Application H14-1219-25
Location Sense 38 Church Street Pinchbeck PE11 3UB
Proposal Change of use to 2 separate dwellings

Name Greg Watkinson
Address Conservation Officer

Date Submitted 22-12-25
For/Against Comments

PROPOSED ELEVATIONS

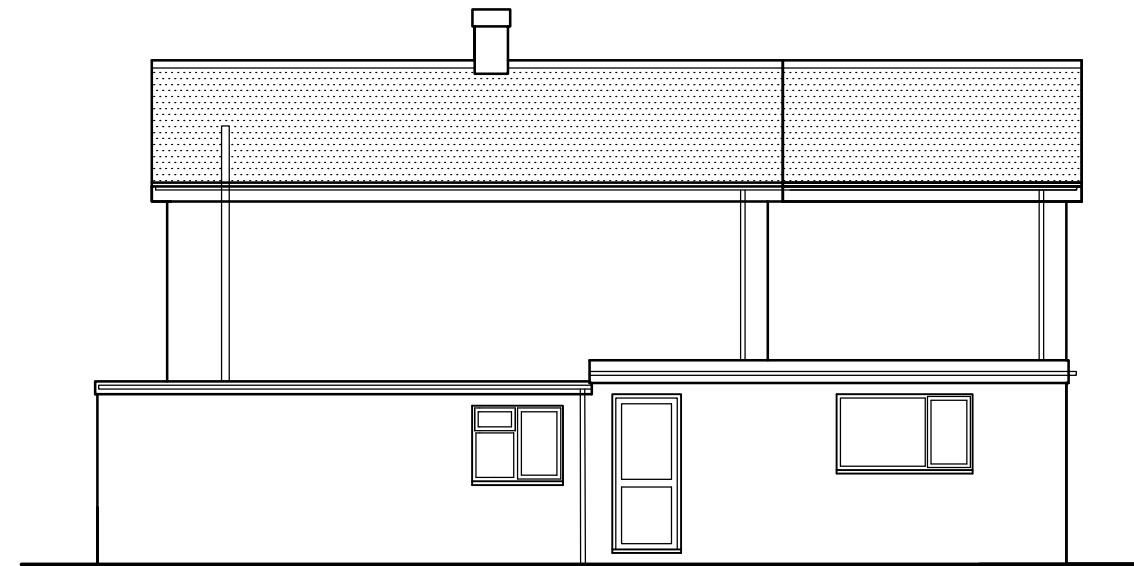
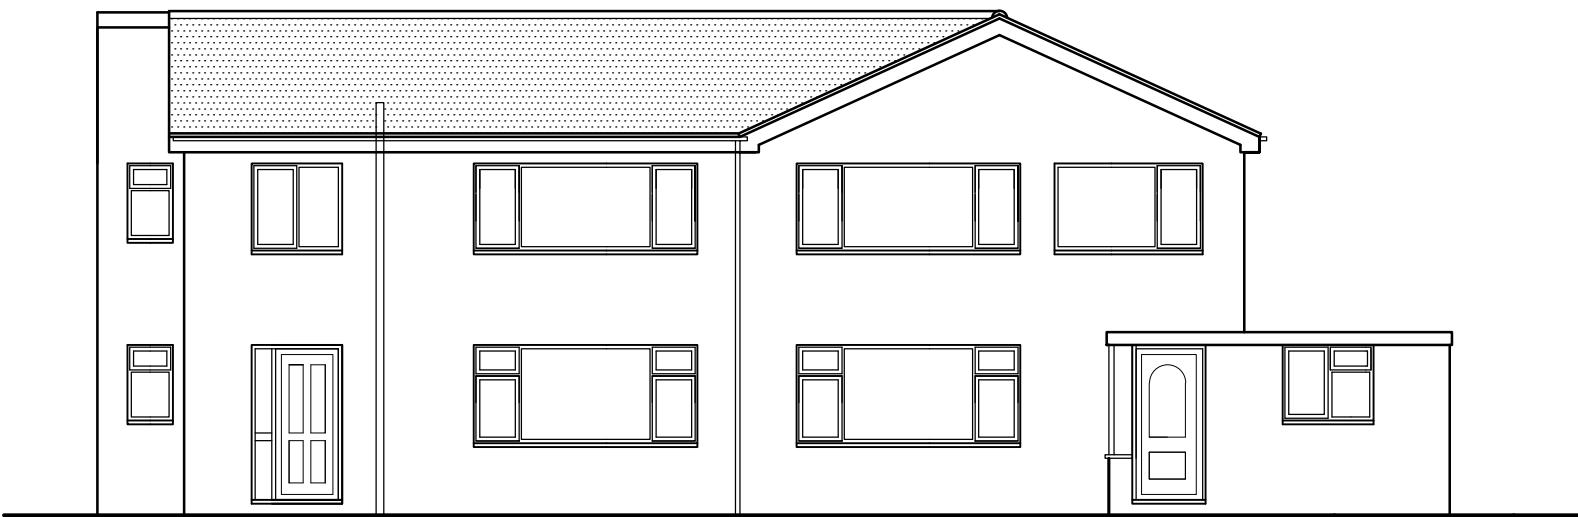
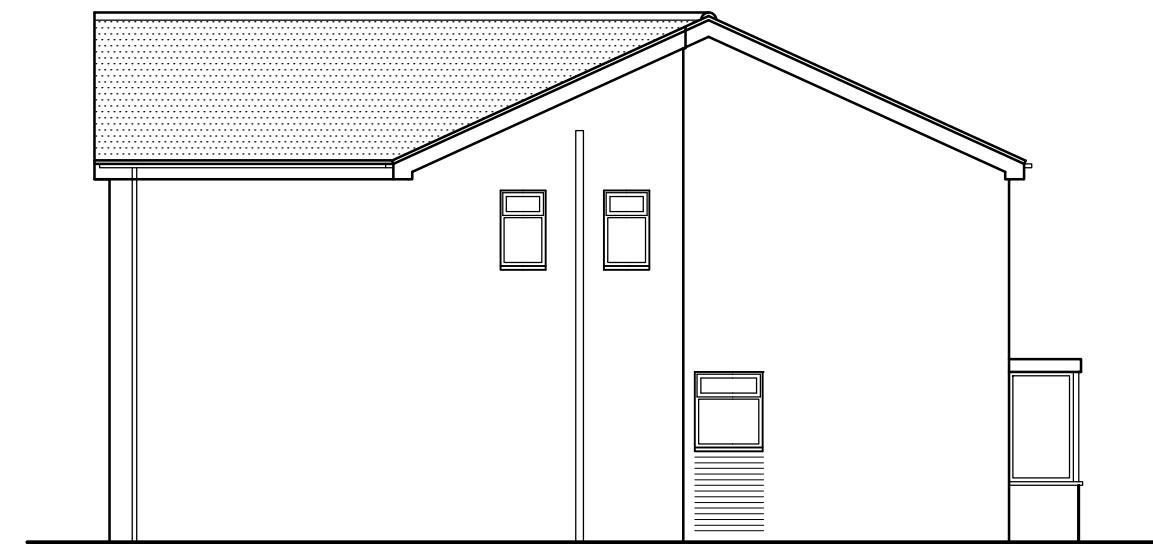
The proposal is mostly in the form of a change of use. However, some small external alterations are included to facilitate this, including the creation of an additional front door, the changing of a side door to a window and the removal of a chimney stack. I consider these works to be extremely minor in terms of potential effect upon the historic environment, to the degree that I do not hold that the proposal risks the character of the setting in any way.

No detail of the proposed new fenestration is included. However, given the extensive use on site already, I assume the proposal is to use PVC units. This would typically not be acceptable in this setting. However, due to the extensive lawful use of such units on site already, it would be unreasonable to require the applicant to conform to a higher standard of fenestration. I would therefore only suggest that the applicant should be required to ensure that the new fenestration matches the existing to avoid creating an unsightly discrepancy on-site.
